SUBJECT: River Wood Short Plat

RE: River Wood Short Plat, File Number SP-07-22

Subject: SP-07-22, River Wood Short Plat (4 Lots); Parcel #20-14-36022-0002
Georgia Chepoda Johnson & Darryl Chepoda
I-90, MP 78.56 – 78.70 Left; Access Via Exit 78 (Golf Course Road)

**RIVER WOOD SHORT PLAT
PART OF SECTION 36, T. 20 N., R. 14 E., W.M.
KITITAS COUNTY, WASHINGTON**

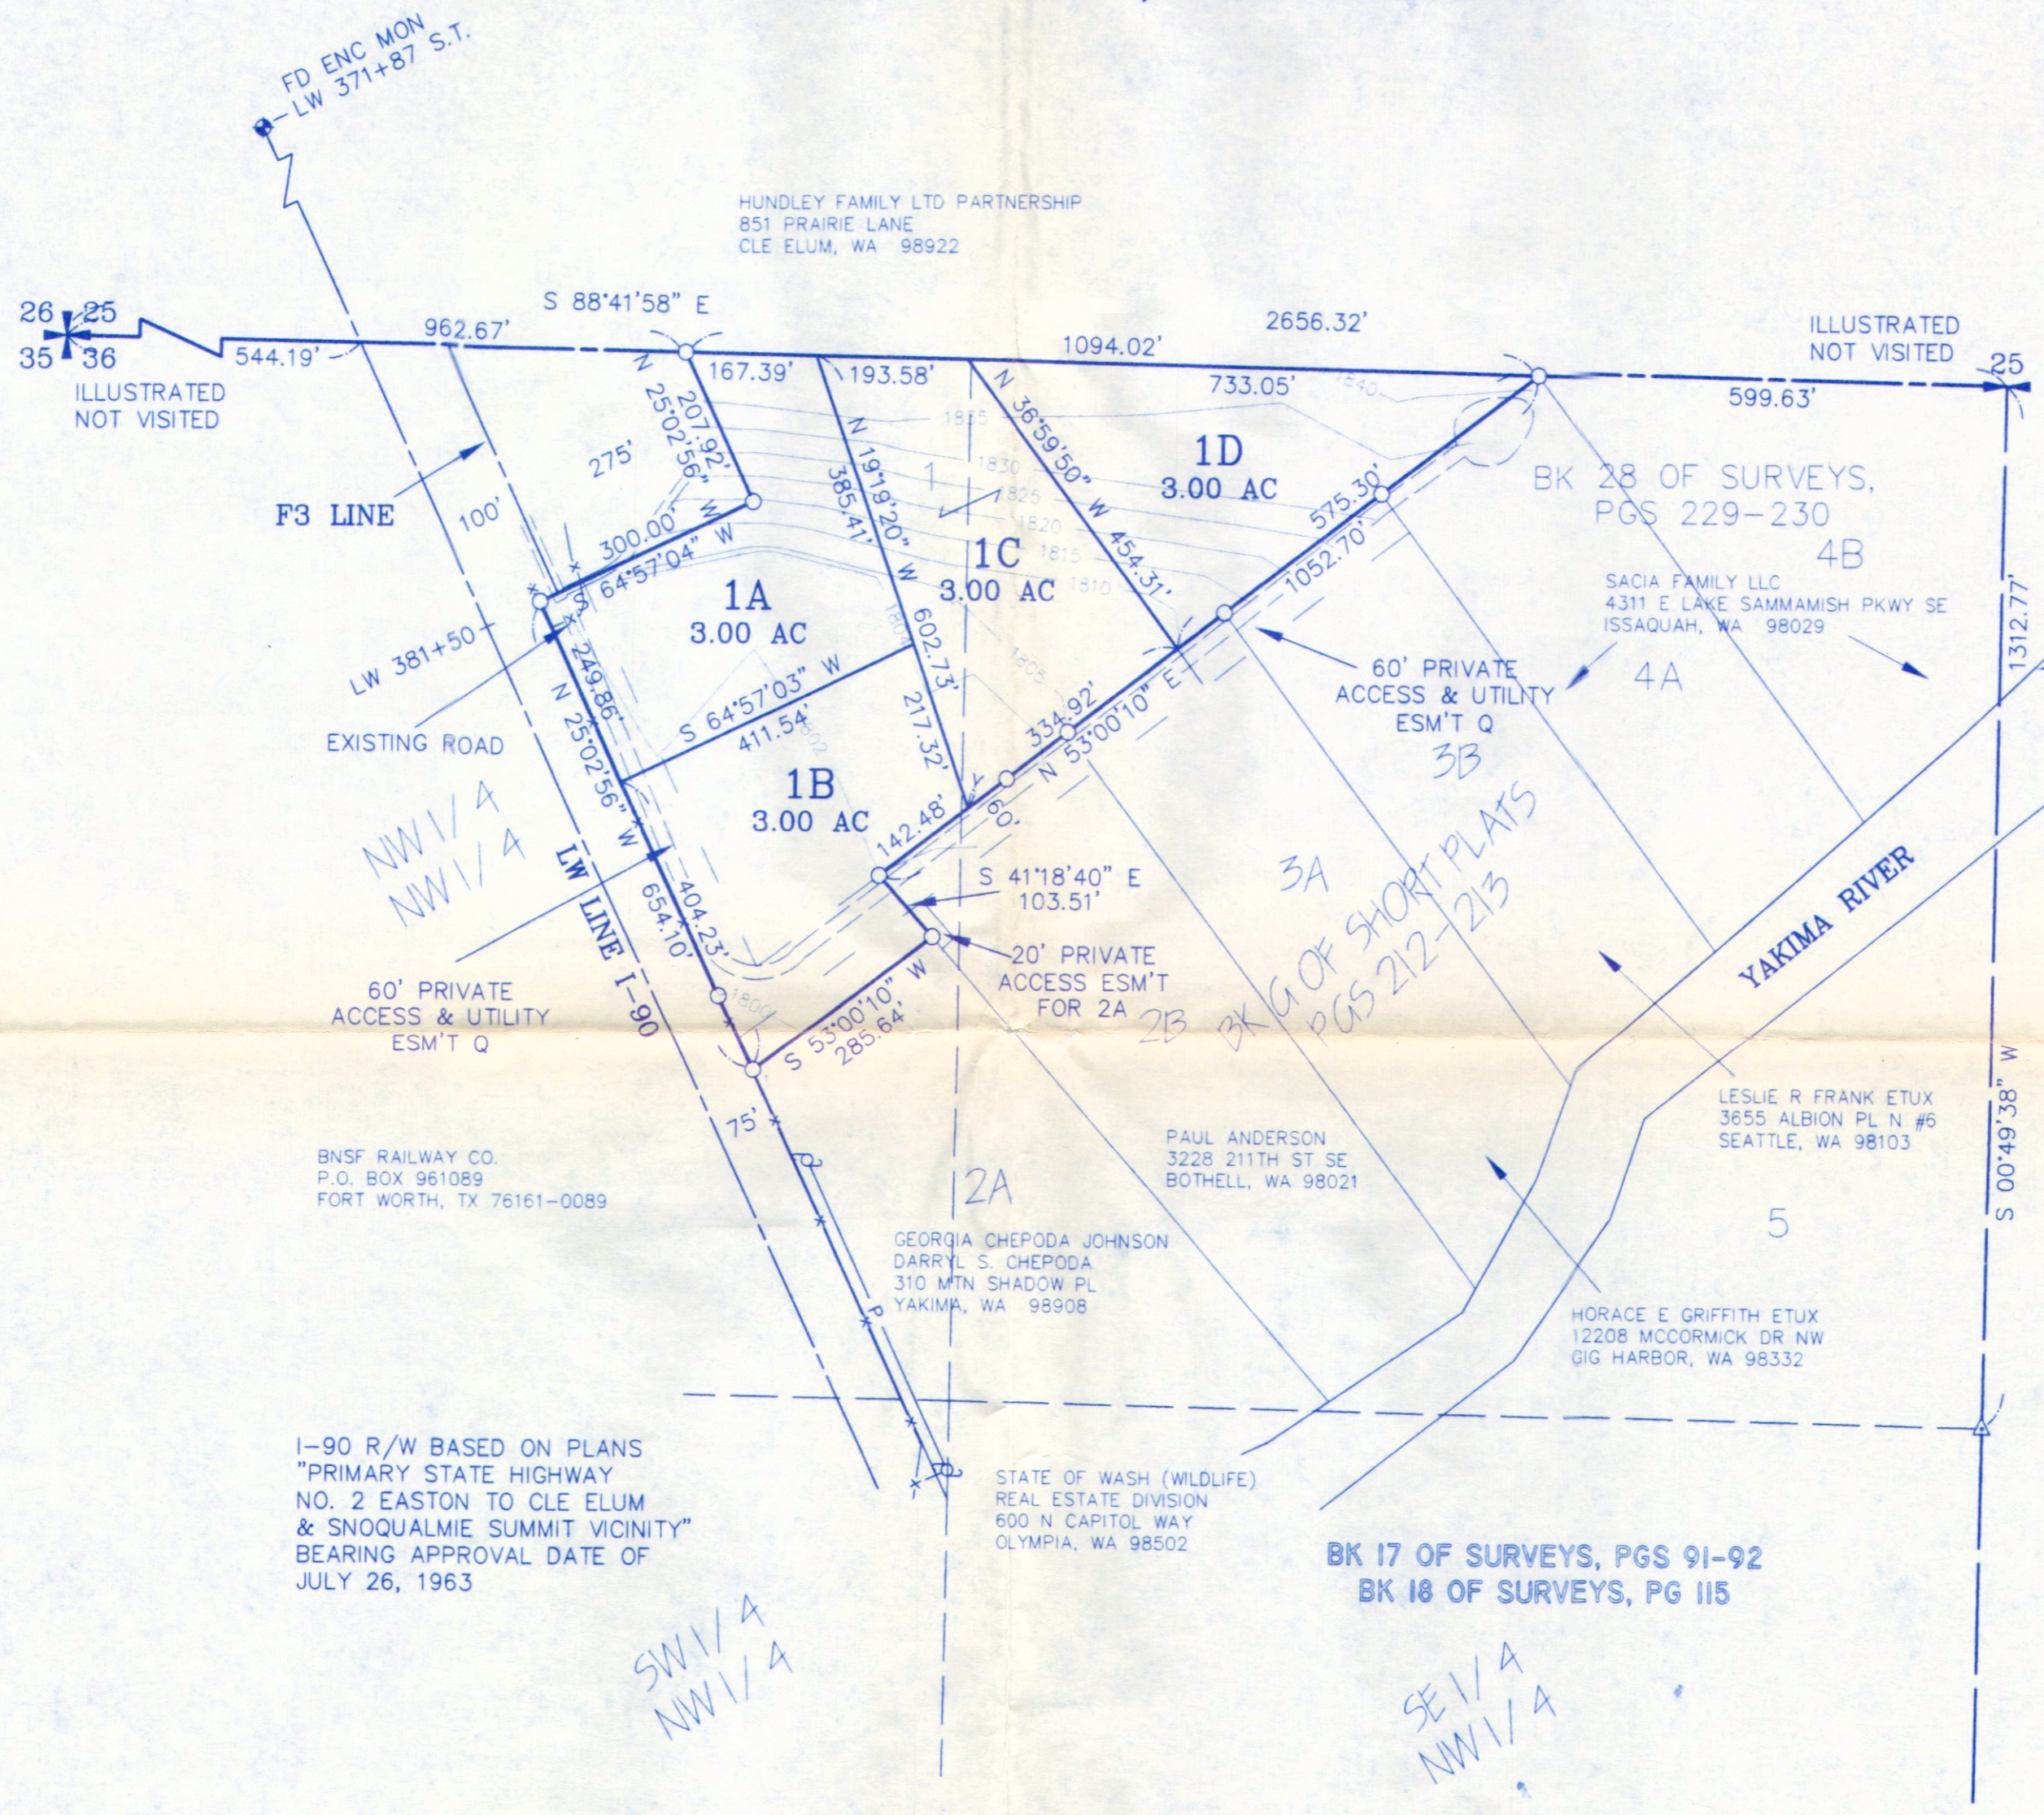
- The cul-de-sac as depicted on the short-plat drawing may not meet IFC turn-around requirements. To ensure that it does, there must be a minimum turning radius of at least 96 feet.
- All development must comply with International Fire Code (IFC) and Appendices.
